HINCKLEY NATIONAL RAIL FREIGHT INTERCHANGE

Applicant's Response to Deadline 4 Submissions [part 11 – Response to Mr Moore and Dr Moore]

Document reference: 18.17

9 February 2024

00:00 on 25/04/2021 to 00:00 on 26/04/2021

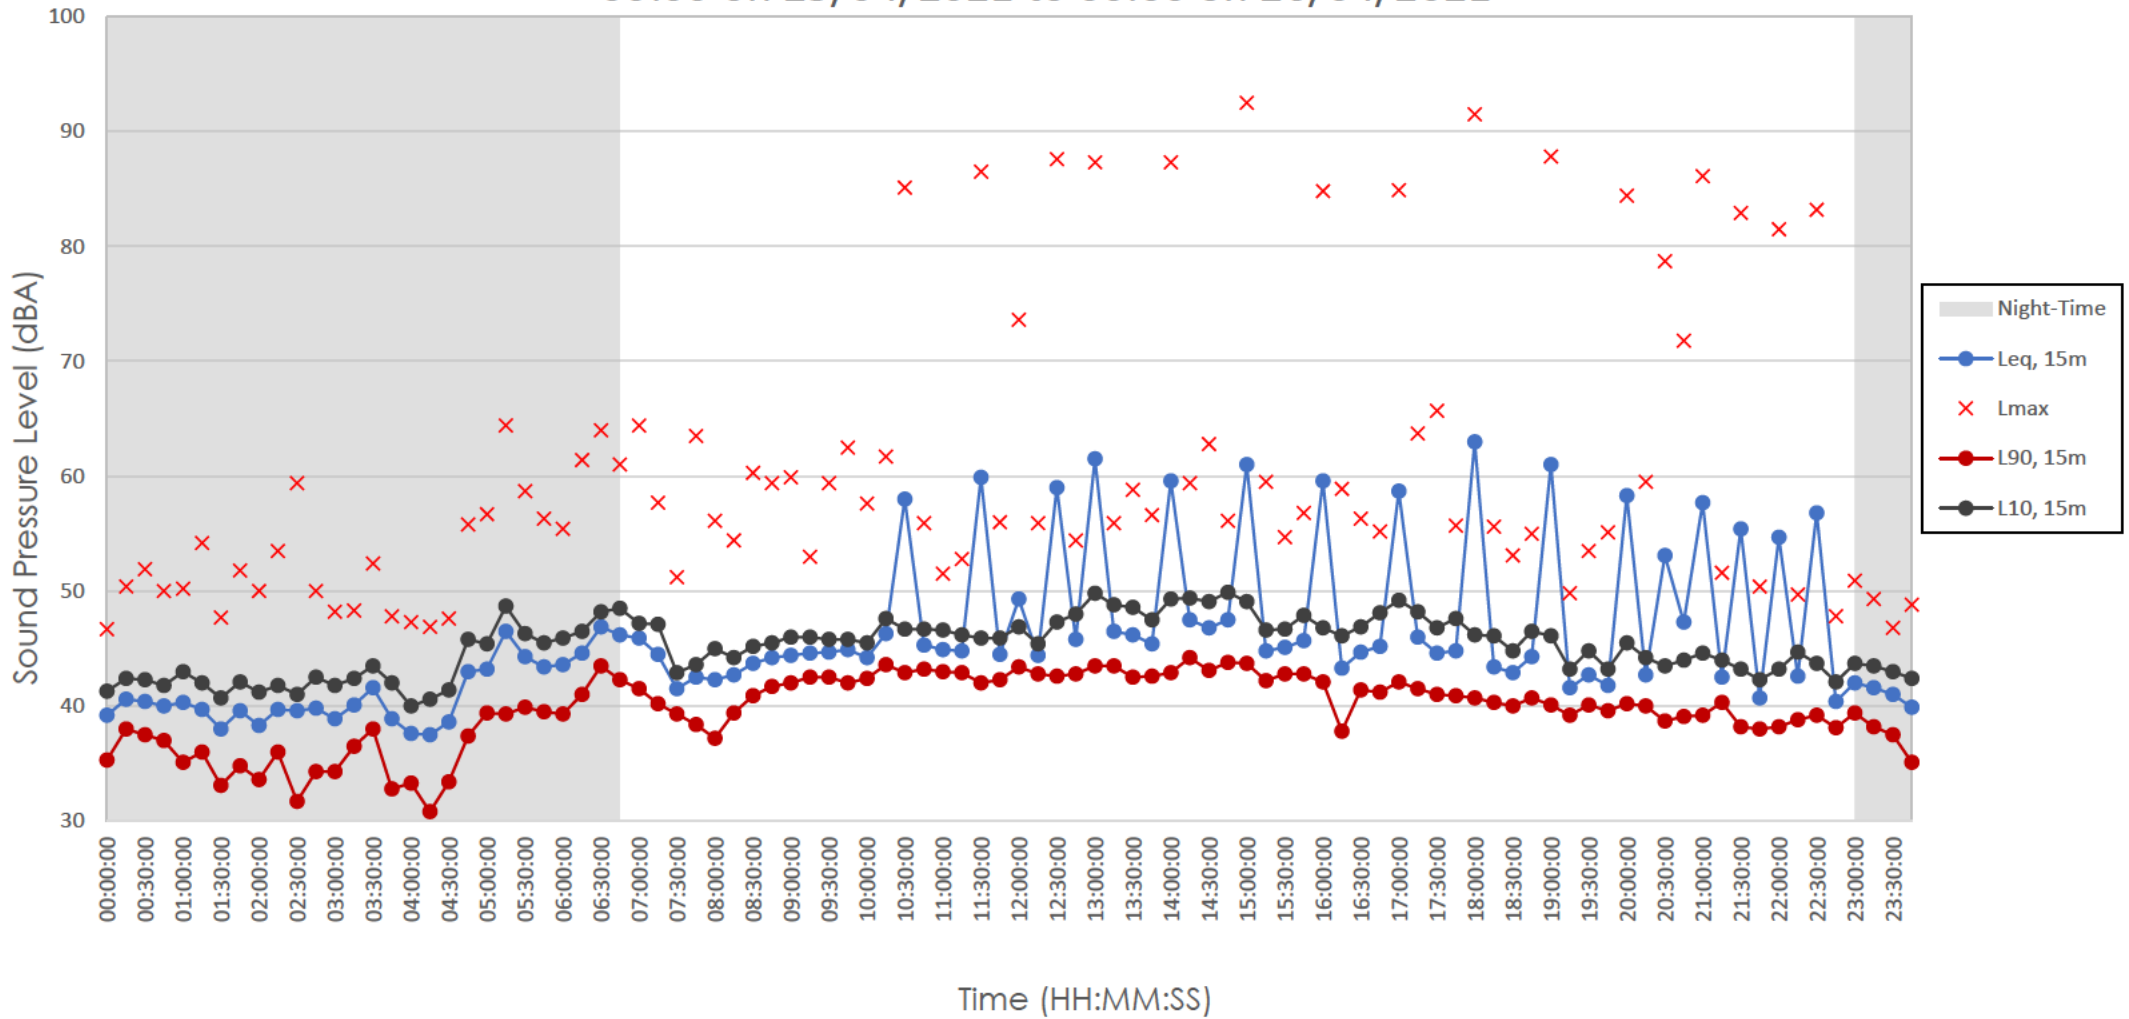
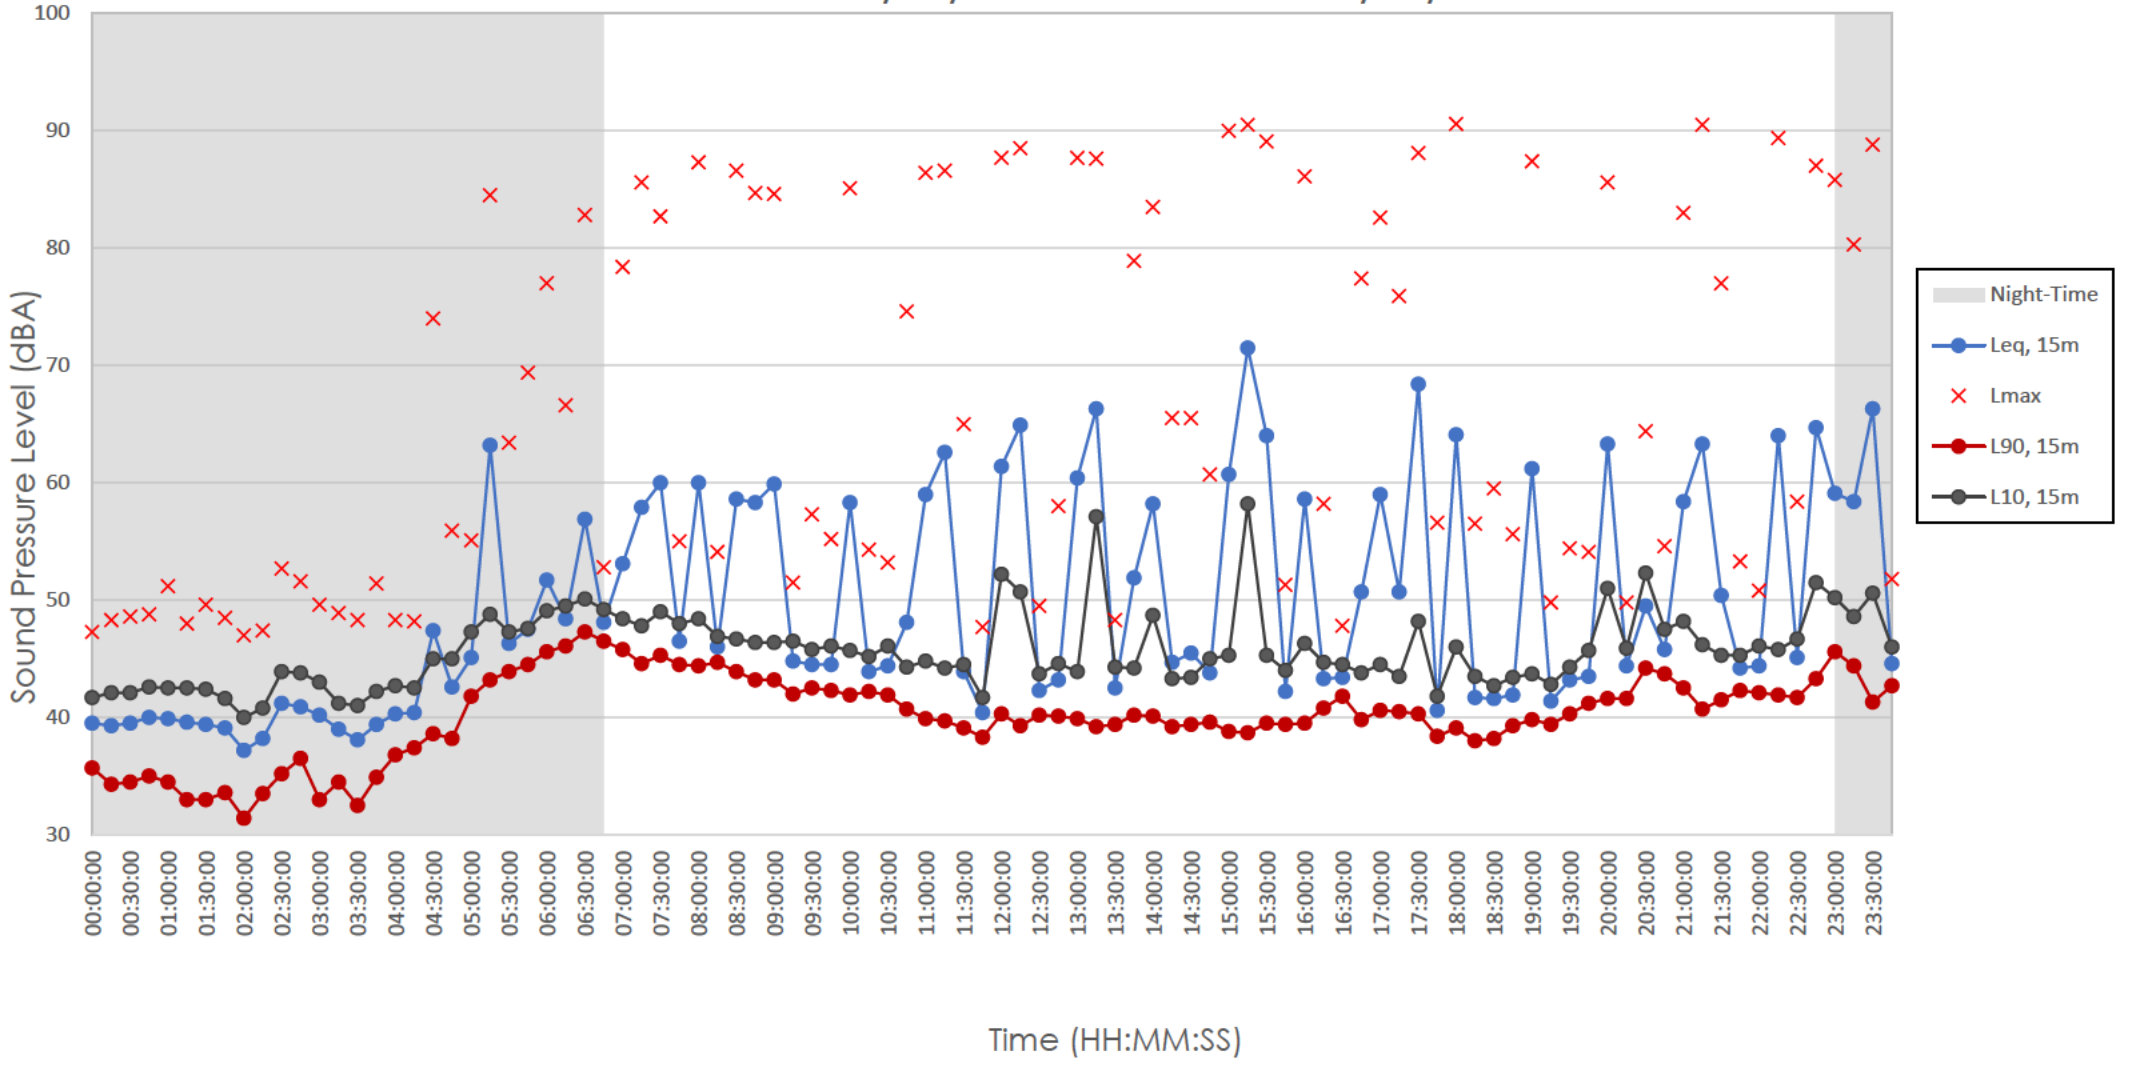
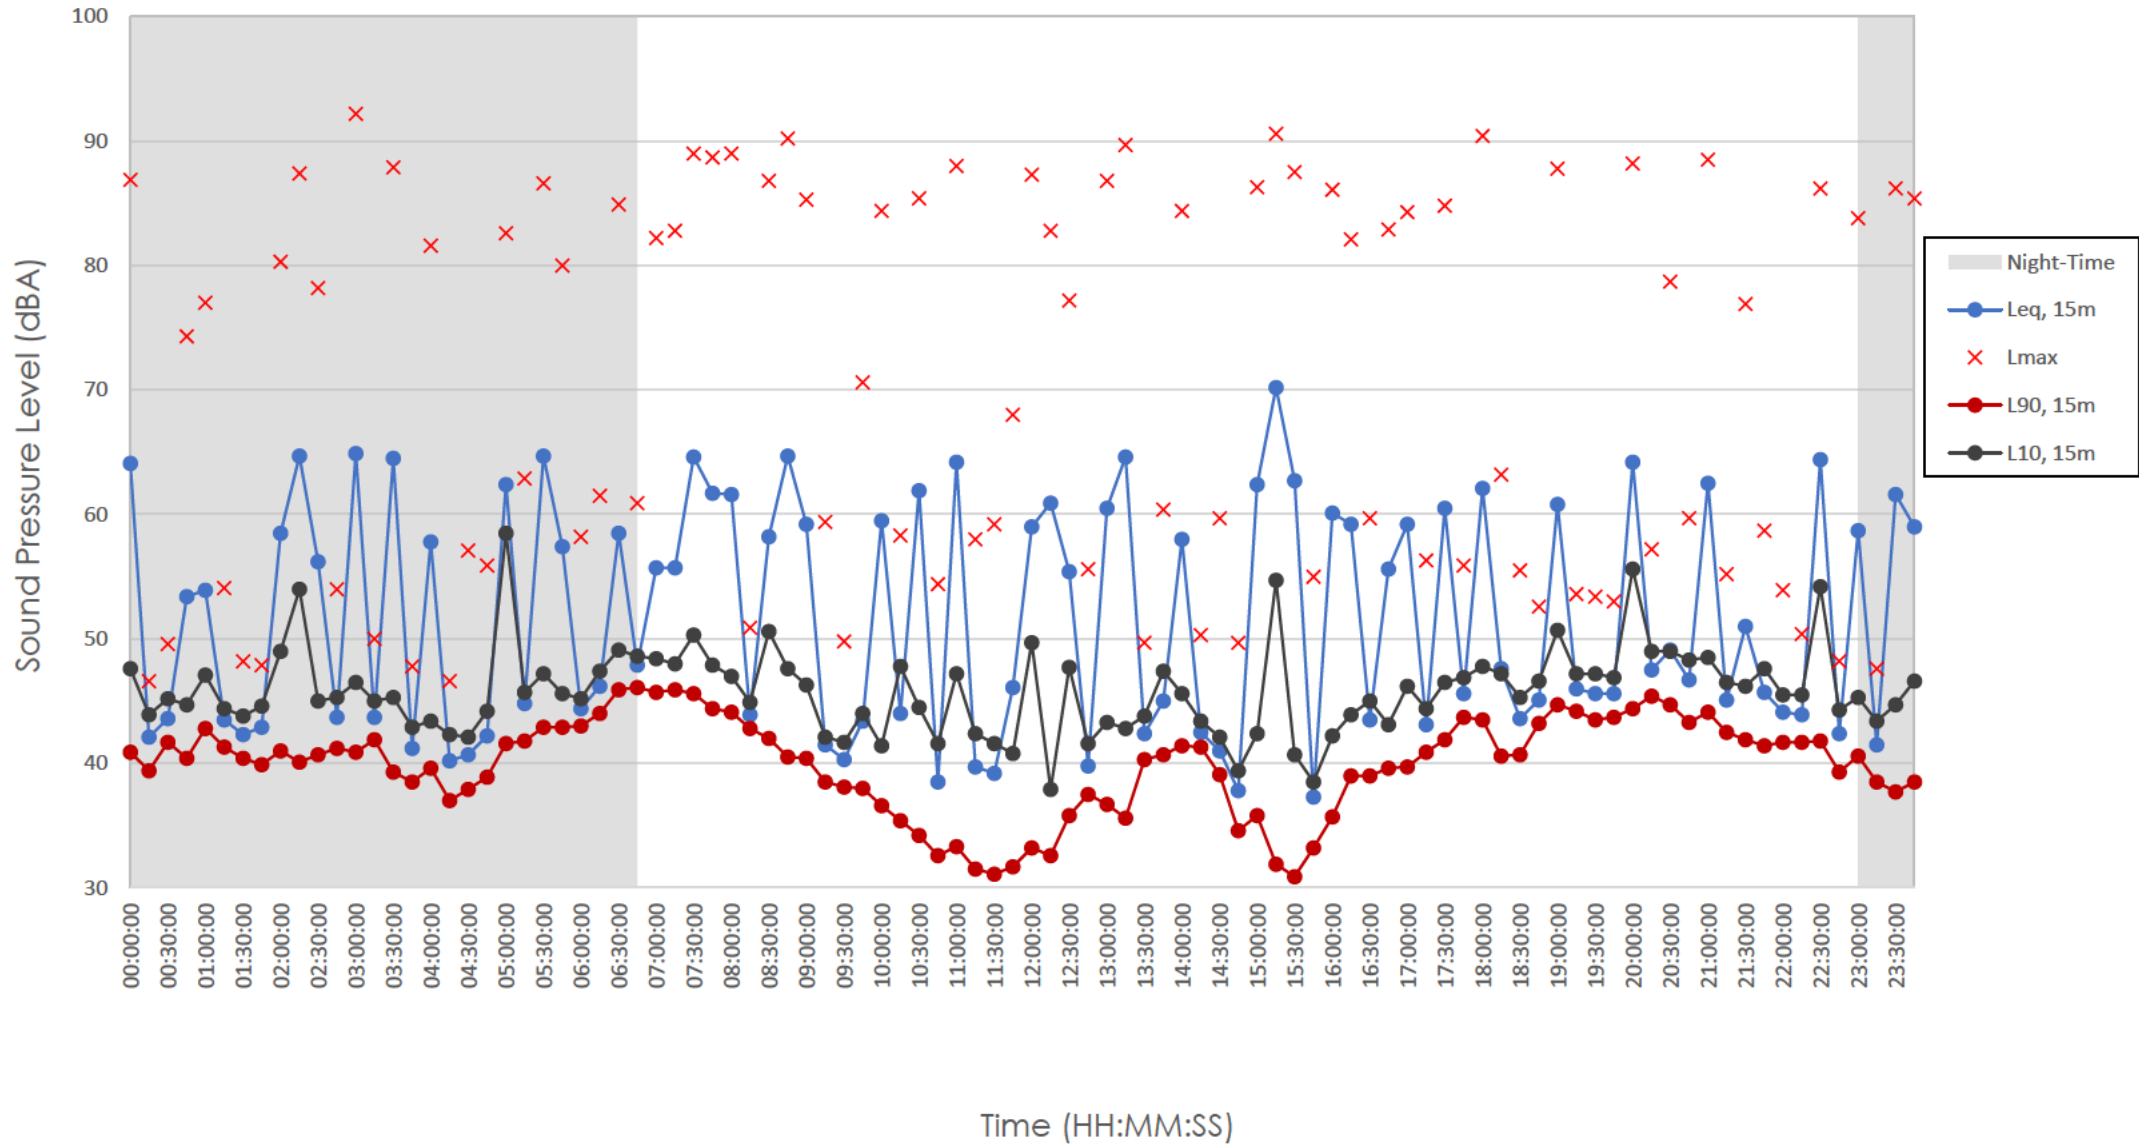
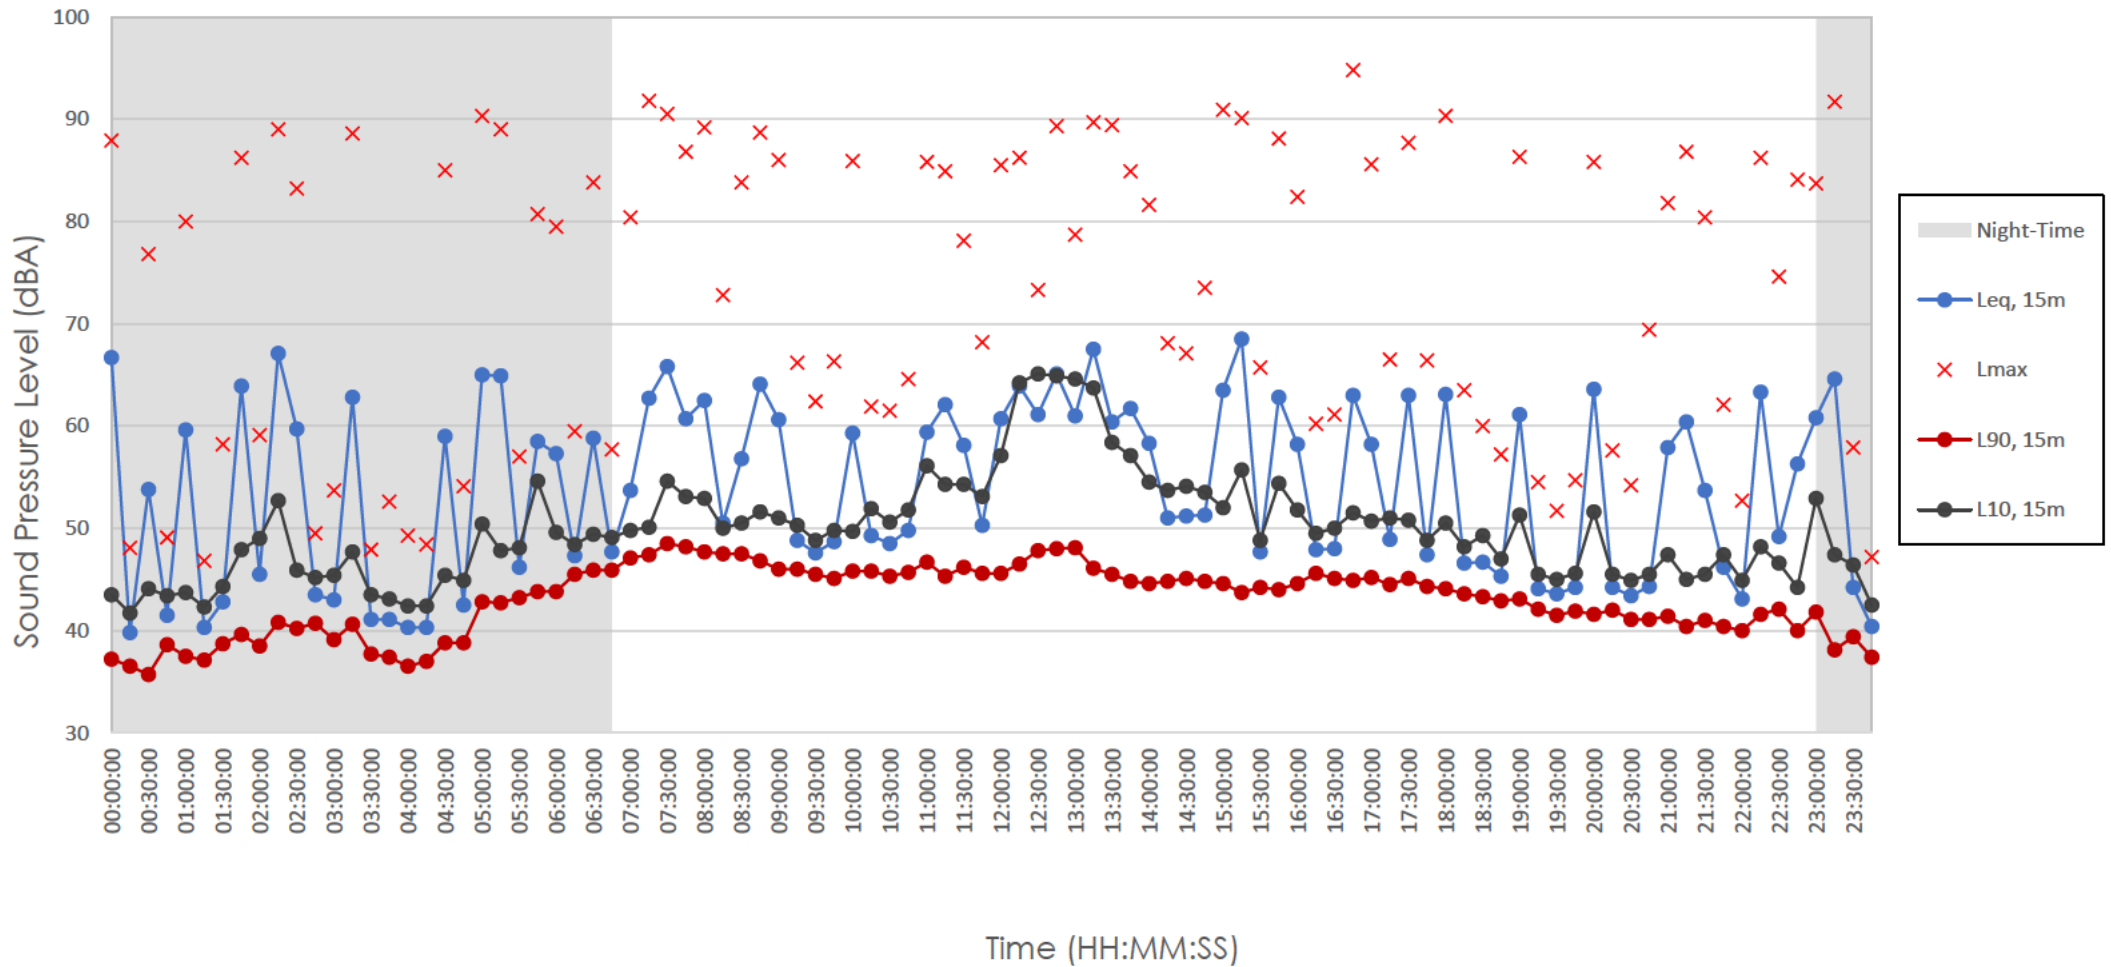
The applicant has submitted a document titled Written Statement of Oral Case ISH3 [Appendix F - Noise Assessment Update Note]. In a roundabout way, the applicant's document attempts to justify the absence of attenuation corrections to the sound of train pass bys measured by NMP4. Rail noise dominates NMP4's ambient sound levels The ambient sound levels measured by NMP4 are utterly dominated by sound of extremely close proximity train pass bys with far lower sound levels when trains aren't passing by, i.e. almost all the time. Overwhelming evidence of this is contained within the summary results pages for NMP4, as explained below in points 1-4. An example summary results page is included in Figure 1, below.

Matter	Applicant's Response
	<p>1. The LAeq sound levels repeatedly spike up and down throughout the daytime and night-time by ~15-20 dB from the low-mid forties, up to 55-65 dB. These spikes are caused by the sound of extremely close proximity train pass bys. Distant road noise would not cause these repeated spikes.</p>	<p>To provide context around the likely existing noise levels from road traffic on the surrounding roads, the baseline 2019 noise model has been reviewed which is based on baseline 2019 traffic data provided by BWB. This does not include any development traffic and purely relates to the existing baseline traffic for 2019.</p>
	<p>2. If these high LAeq sound levels were caused by the distant road noise we would always see the LA10 levels spiking along with the LAeq levels, but we don't because they're caused by train pass bys and train pass bys are inherently brief.</p>	<p>The model only includes those roads that are within the study area for noise and therefore does not include all of the surrounding roads.</p>

<p>3. If these spikes were caused by changes in the distant road noise, we would see significant changes up and down in LA90 levels, but we don't because they're caused by train pass bys and train pass bys are inherently brief. This is why there's a gap of 20 dB between the weekday daytime background sound level in the report and the weekday daytime ambient sound level in the report. The train pass bys have no impact on the measured background sound levels, which contain the distant road noise. This is why NMP4's measured background sound levels can simply be copied to NSRs 1-8 & 24-26.</p>	<p>Using these two sources, it is possible to determine the ambient noise levels in the vicinity of receptors located further away from the railway line, by essentially logarithmically summing the noise level from the rail line with the noise level as a result of road traffic. The results of this calculation are shown in Table 4 within Written Statement of Oral Case ISH3 [Appendix F - Noise Assessment Update Note] (document reference: 18.7.6, REP3-061)</p>

<p>4. The spread between the LA90 levels, LAeq levels, and LA10 levels is very tight in those 15 minute periods which don't contain spikes in LAeq levels. This is because these time periods are dominated by the distant road noise in the low-mid forties dB. The gap between the LA90 levels and the LA10 levels remains stable during periods with spikes in LAeq levels because the distant road noise is stable.</p>	<p>This analysis indicates that as distance increases from the rail line, road traffic from surrounding roads becomes more dominant. The predicted cumulative noise levels from these sources are within an acceptable range (1dB) of noise levels used within the assessment, and therefore the results and conclusions stated within Chapter 10 Noise and Vibration (document reference: 6.1.10A, REP4-039), remain valid.</p>

A response to this question was provided at Deadline 3 and is detailed within Written Statement of Oral Case ISH3 [Appendix F - Noise Assessment Update Note] (document 18.7.6, REP3-061). The response is summarised below.

The latest available DEFRA noise mapping data for the rail line has been reviewed and aligns with the noise levels measured at NMP4.
